Subject: RE: Planning application at Moss View, Burnlee Road Holmfirth

Bridges & Structures Manager
Structures Section
Highways and Streetscene
Kirklees Council

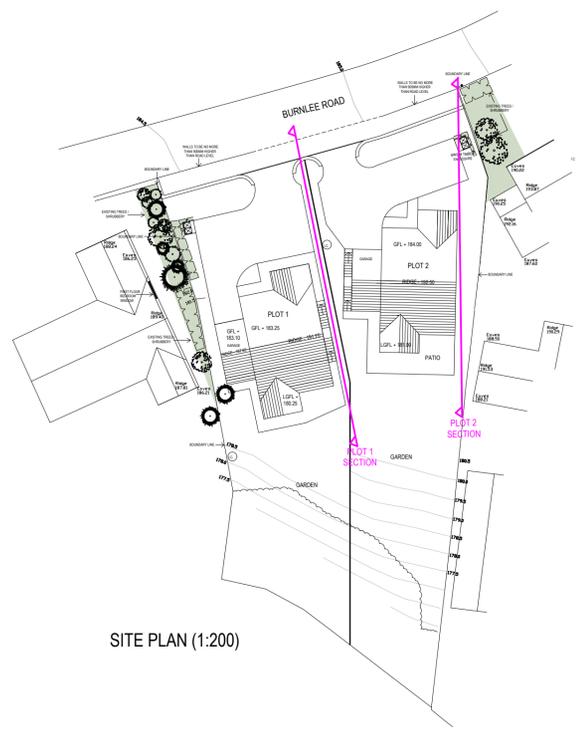
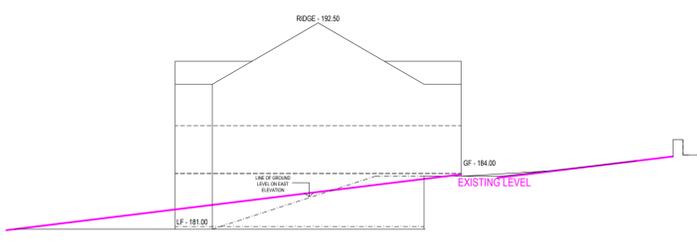
- 1) Before the development commences, the proposed design on new retaining walls including any modification to the existing highway burr wall supporting Burnlee Road shall be submitted (via submission of an AIP) and approved by the Highway Authority in writing. The approved scheme shall be implemented prior to the commencement of the proposed development and thereafter retained during the life of the development.
